September 5, 2023

Project Name / File No.: E Sunnyside PRD / PA22-033
Applicant: JM1 Holdings, LLC
Project Description: 27 Lot PRD-Subdivision
Re: Response to 1st Review Comments

This letter serves as the Applicant's formal response to the 2nd review comments received on March 20, 2023, to our recent application materials submitted to the City of Marysville. To ensure that each of the comments have been responded to, we have incorporated each of the City's comments along with the Applicant's response to each below.

NATURAL 9 HOLDINGS, LLC
E SUNNYSIDE PRD
PERLIMINARY GRADING PLAN

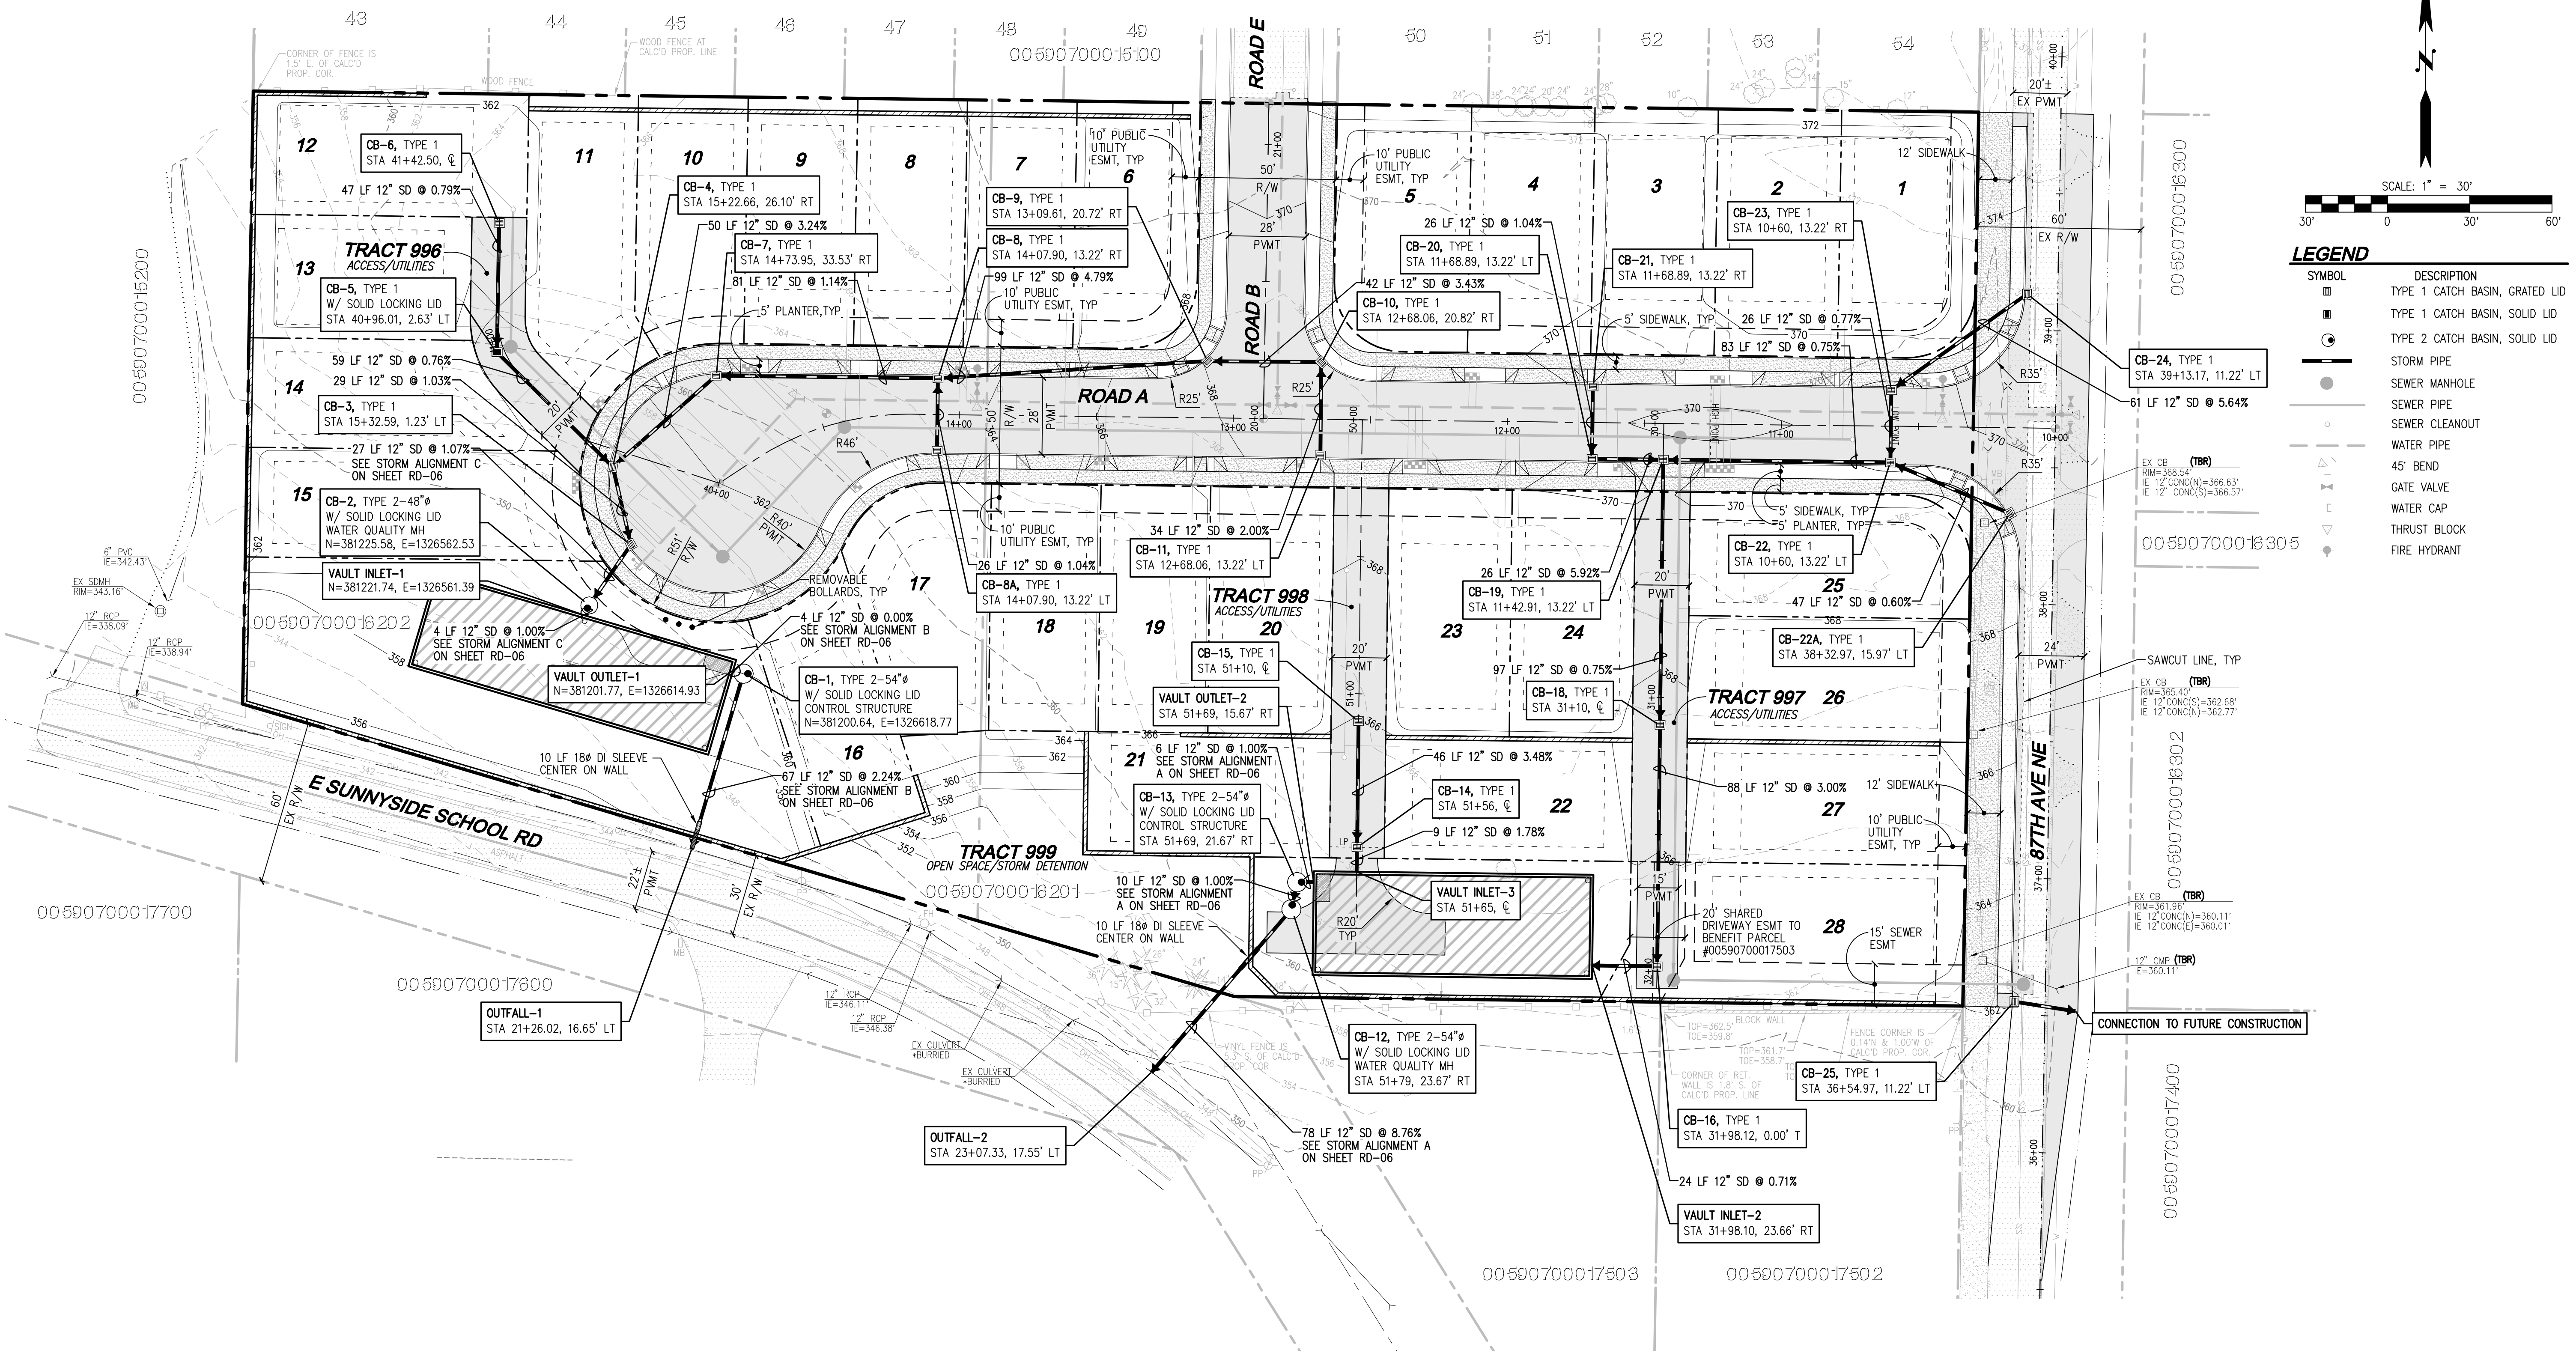
1. Modify the proposed grades so that the development can follow the natural topography of the site to the maximum extent feasible (MMC 22D.050.030(4)). Eliminate, or reduce the height of the terraced retaining walls along Tract 999.

2. Modify the proposed modification of Lots 8-16 to eliminate the need for or reduce the height of the proposed retaining wall. Suitable house plans may propose basement (tuck-under) garages to fit the natural topography.

3. Modify the grades for Lots 19 – 21, eliminating the proposed walls and follow the natural topography of the site to the maximum extent feasible.

Applicant's Response: Site has been regraded with the majority of the westerly lots consisting of "tall crawl" building pads. This has eliminated much of the new walls along the westerly and southerly boundary lines of the site. Max wall heights along these property lines are limited to 4' in height. As for walls along the northern portion of the site, it is our understanding that the wall heights as previously designed can remain per meeting with City.

Applicant's Response: As noted above, Lots 8-16 have been redesigned with "tall crawl" building pads in order to better blend future houses into the natural topography of the site.

Applicant's Response: Grades have been modified to reduce the majority of walls adjacent to these lots.

TYPICAL TRACT SECTION
SCALE: 1"=5'

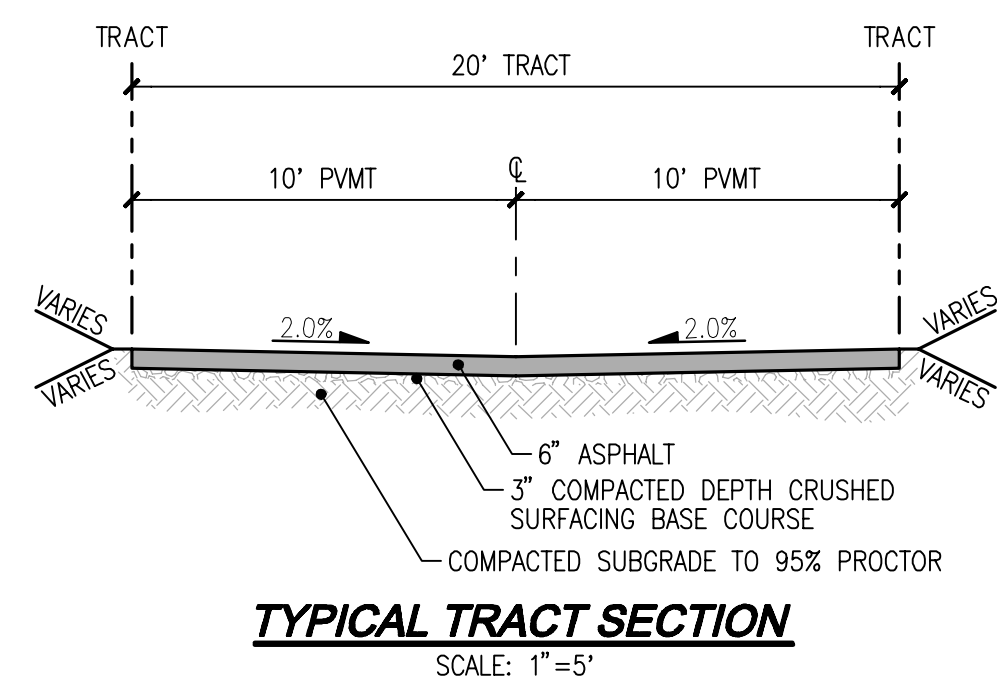
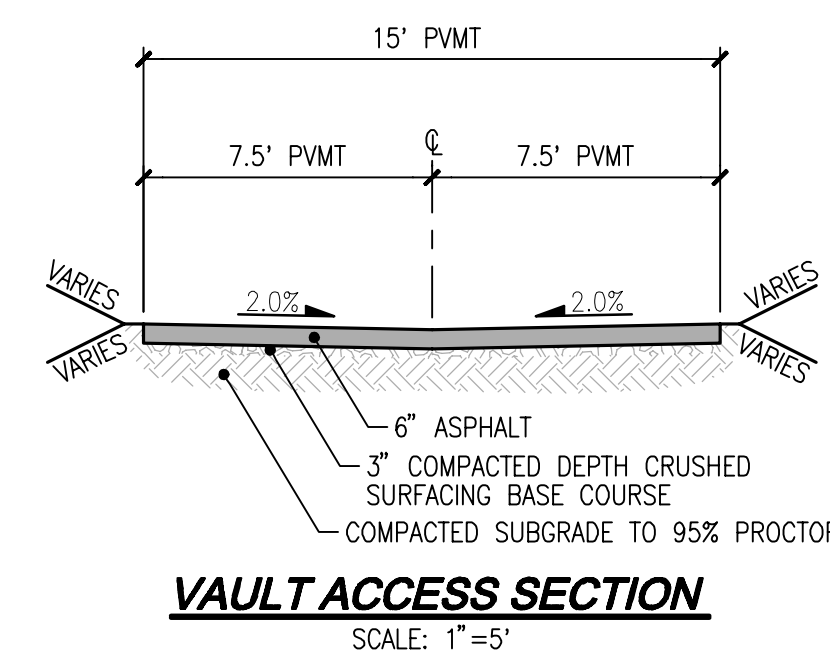
12. Tracts 996, 997, and 998 are required to be surfaced with scored concrete, paving blocks, bricks, or other ornamental pavers to clearly indicate that the entire surface is intended for pedestrians as well as vehicles. Update the preliminary civil and landscape plans to reflect this change.

Applicant's Response: Plan view hatching has been revised to differ it from new concrete and asphalt areas. Section details have been updated to note scored concrete, paving blocks or other types of surfaces per engineering standards verbiage.

E SUNNYSIDE PRD BINDING SITE PLAN

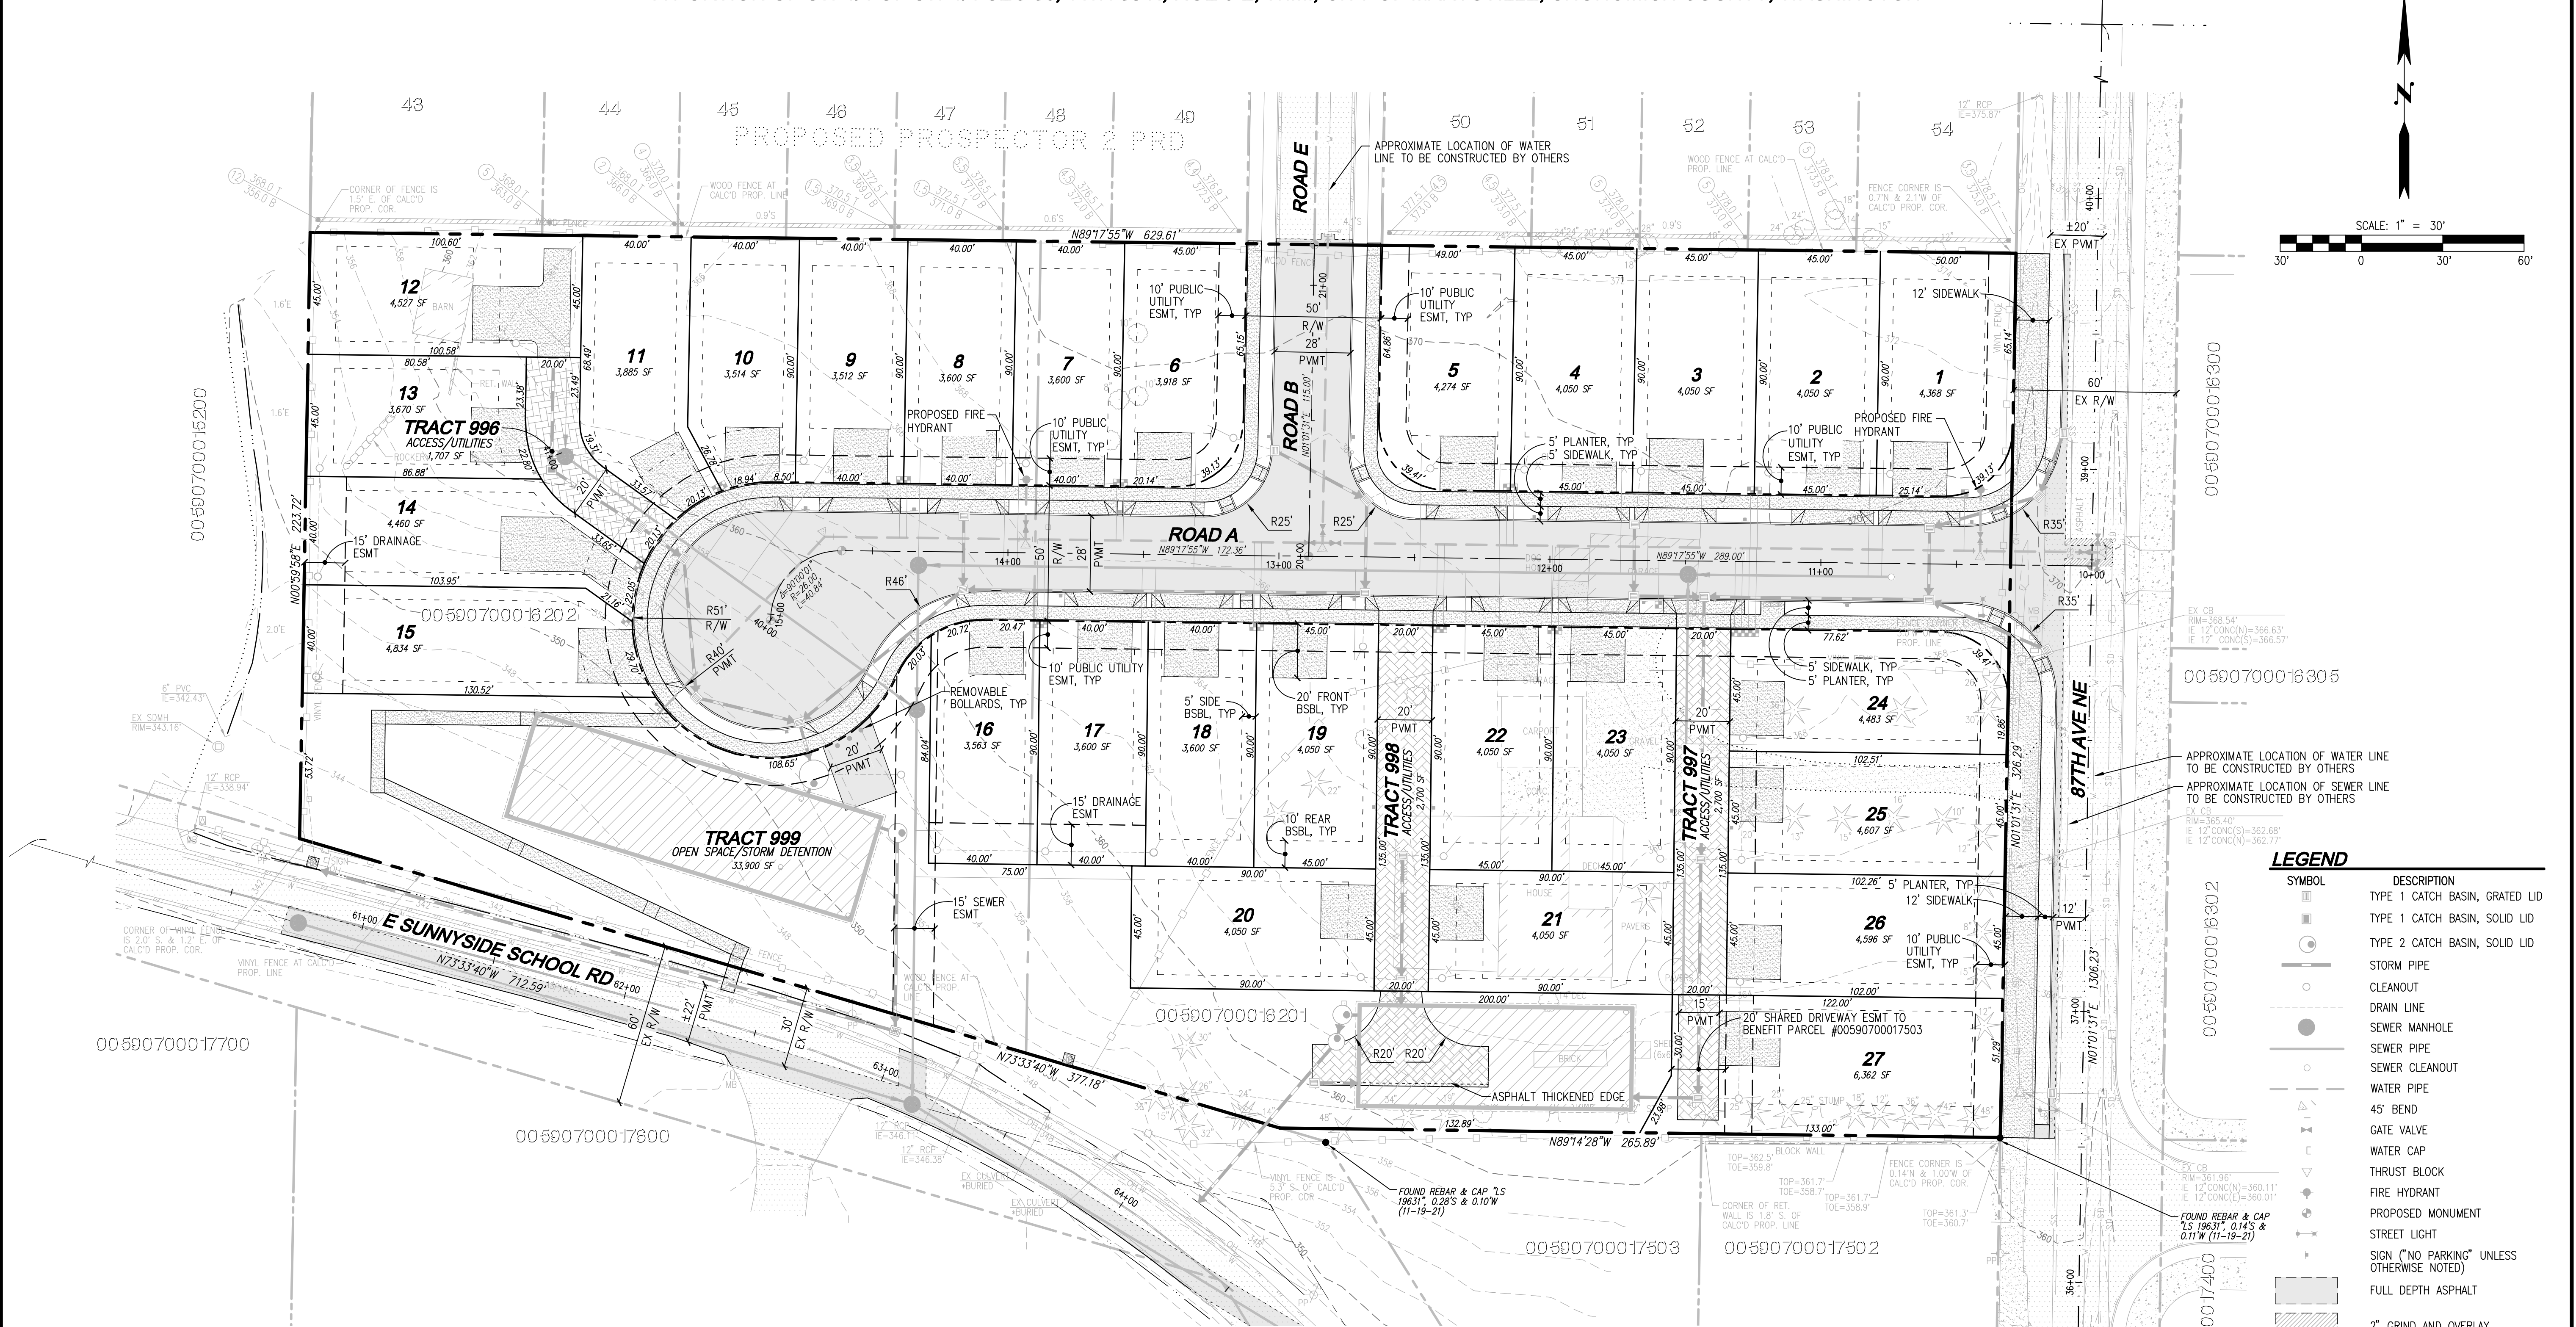
8. Lot 10 does not meet the minimum lot size of 3,500 square feet.

9. In addition to the right-of-way, the following must be deducted from the gross project area: access easements, private roads, and the panhandle serving lot 16. Alternatively, you may choose to take a flat 20% deduction.

11. In the title, replace "Plat" with "Binding Site Plan".

Applicant's Response: Lot 10 adjusted so lot is greater than 3,500 sf. in size.

Applicant's Response: We have elected to use the flat 20% deduction from gross area in order to calculate net area. 20% reduction has resulted in one less lot available for development along with less open space area being required. Refer to revised Binding Site Plan for updates calculations.

Applicant's Response: Plat has been renamed to a Binding Site Plan.
